**Consultation Response from KC,  
Lead Local Flood Authority**

**2024/92548 40, Bradford Road, Fartown, Huddersfield, HD1 6JE**

**Change of use of dwelling to 10 bed House of Multiple occupation including erection of 3 storey extension and associated alterations'**

**Date Responded: 02/12/2024.**

PROPOSED BASEMENT FLOOR
SCALE 1:100 AT A3

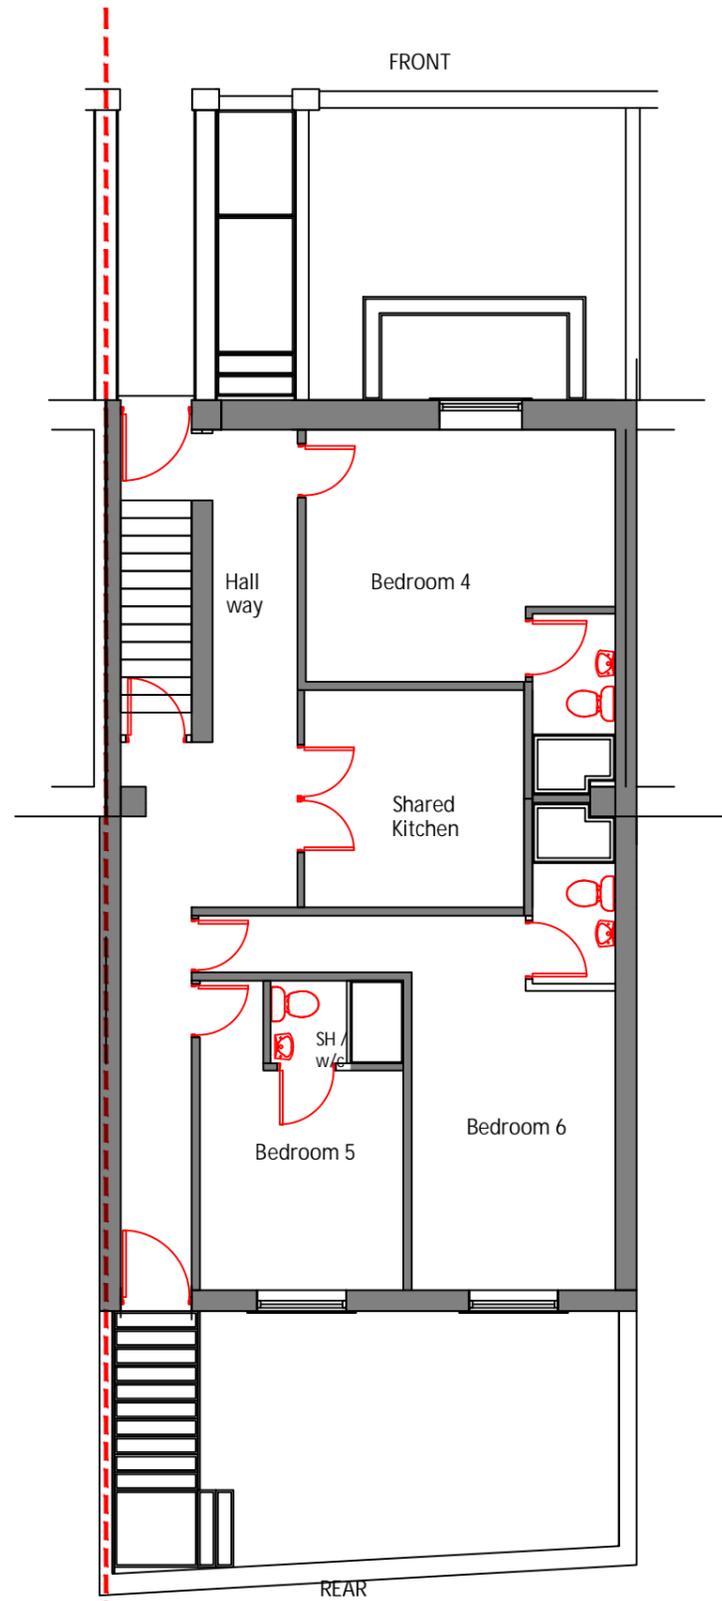
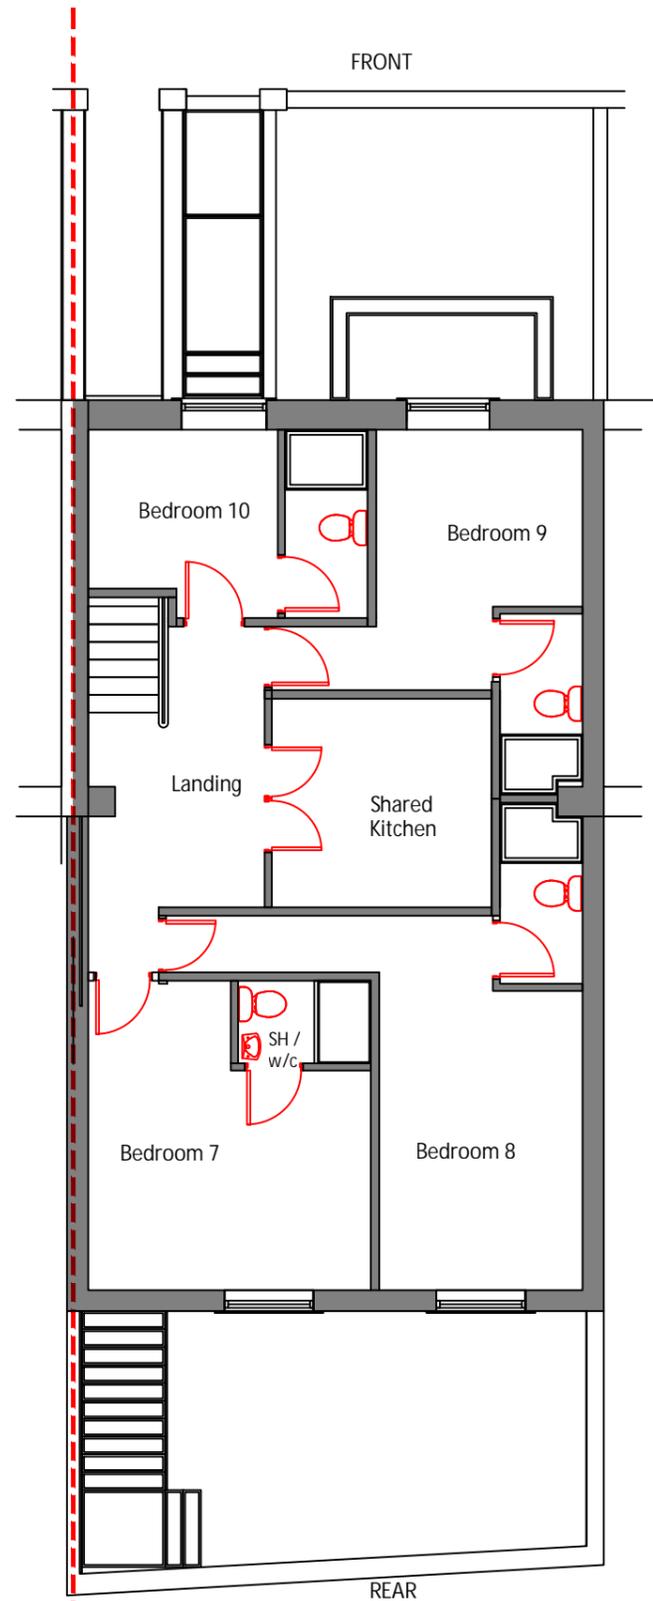
It is noted that the proposed basement arrangement shown on the Proposed Floor Plans drawing indicates that the basement floor level will be converted into 3 bedrooms and a shared kitchen. Although there is a means to escape to the upper floors in the event of flooding, there is a serious risk that residents could be asleep and unaware of the potential danger.

Therefore, the LLFA considers that the risk to life for residents occupying the basement level bedrooms is unacceptable.

**Kirklees Flood Management & Drainage as Lead Local Flood Authority OBJECTS to this application on the grounds of unacceptable flood risk.**
